Application for a Non-Material Amendment Following a Grant of Planning Permission

Proposal for New Medical Centre and Demolition of Existing Sub Station

22/00646/FUL

DWG TITLE
Proposed East Elevation

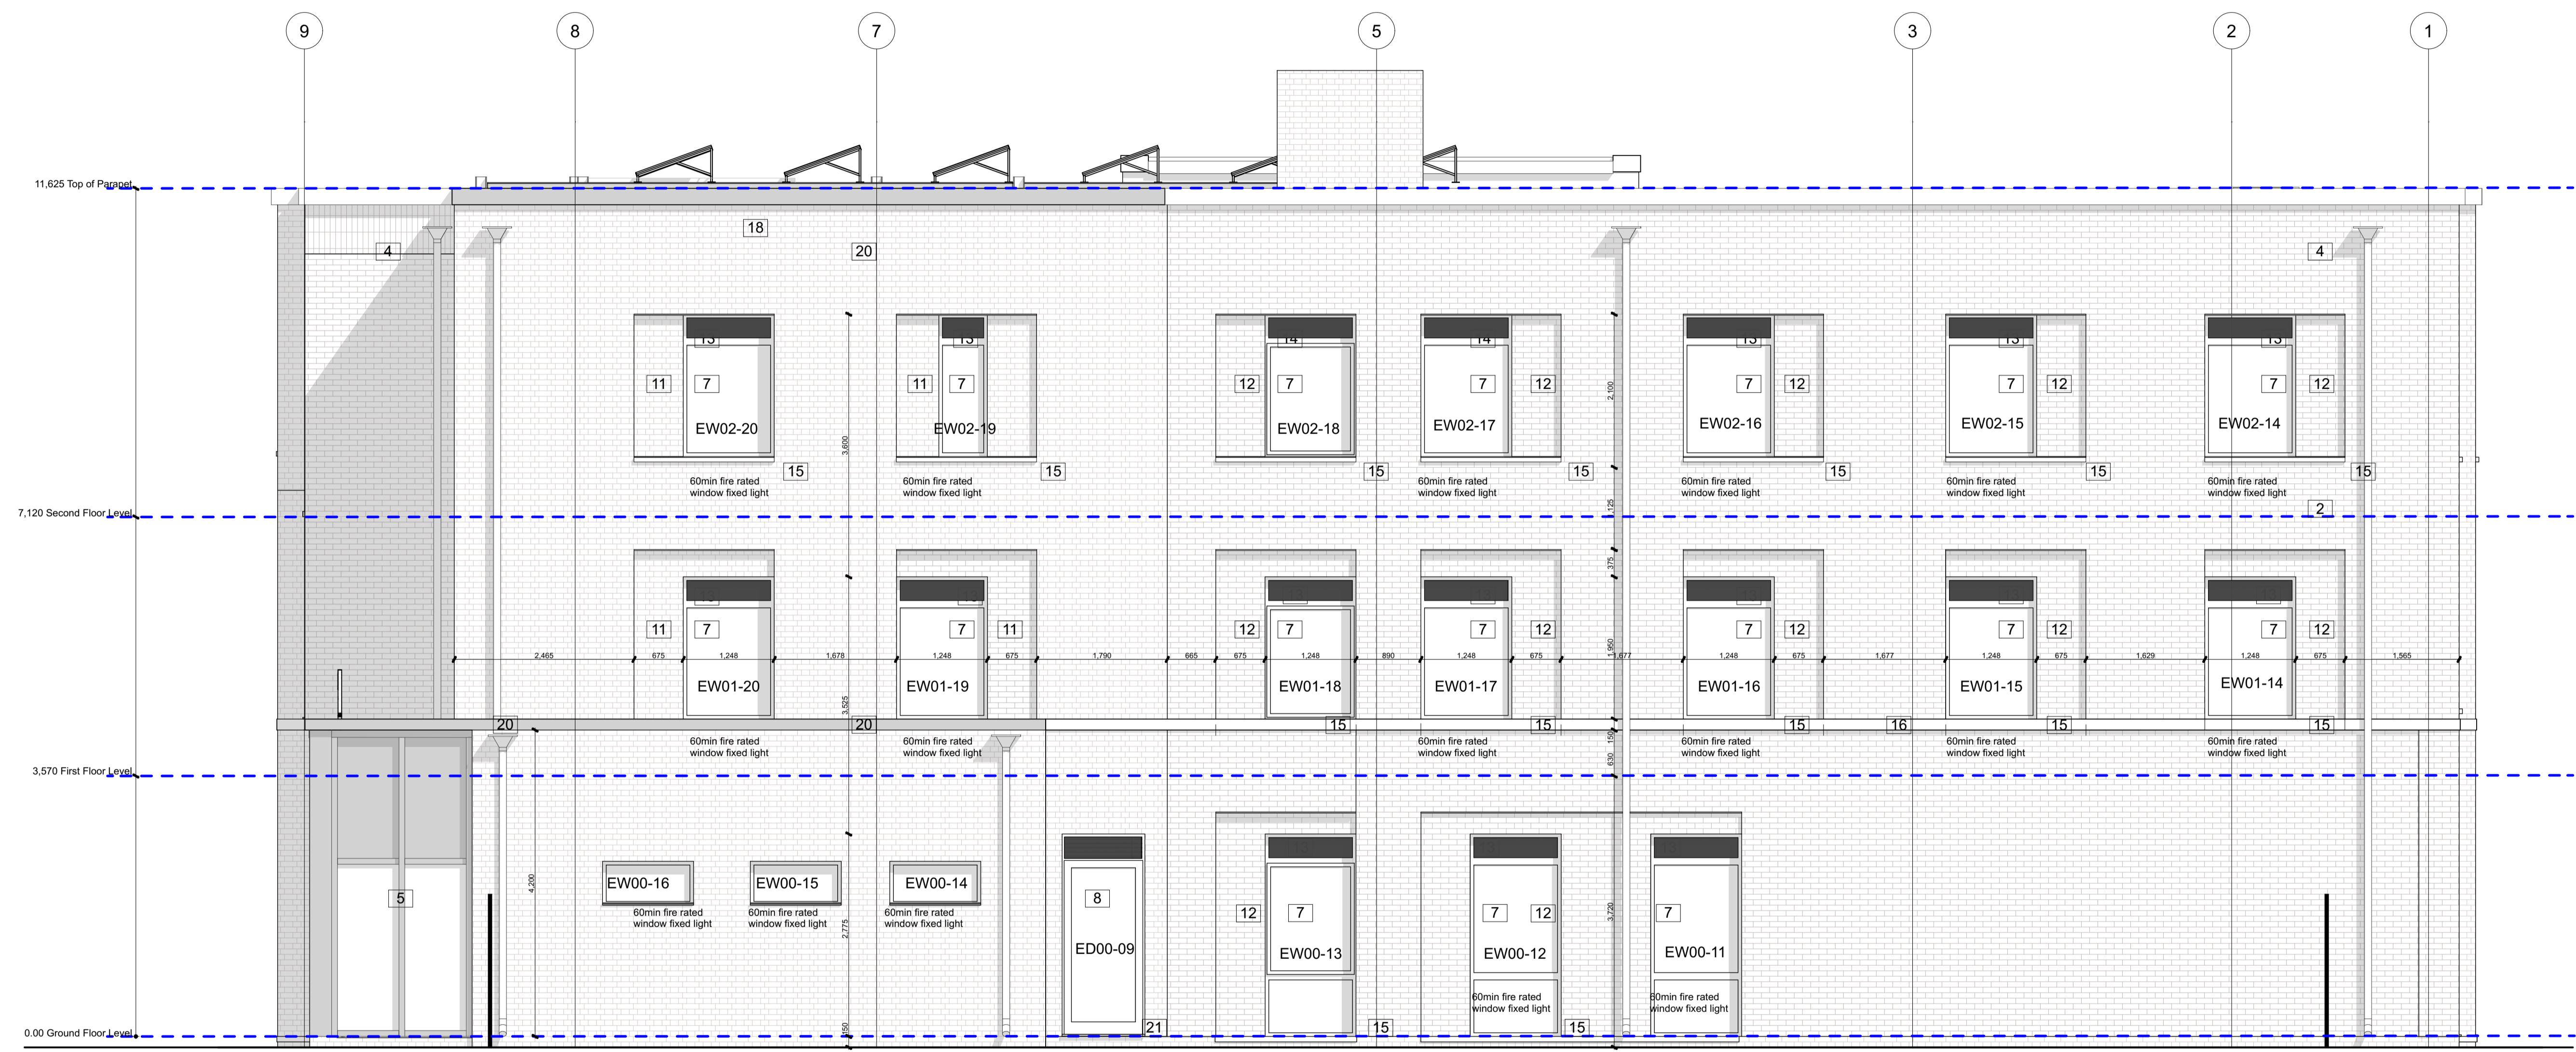
Increase the overall height of the proposals.

Due to the technical development of the scheme we have needed to increase the individual floor build ups and therefore the overall building height to allow for the structure and ventilation requirements. The overall height of the building has increased by 825mm.
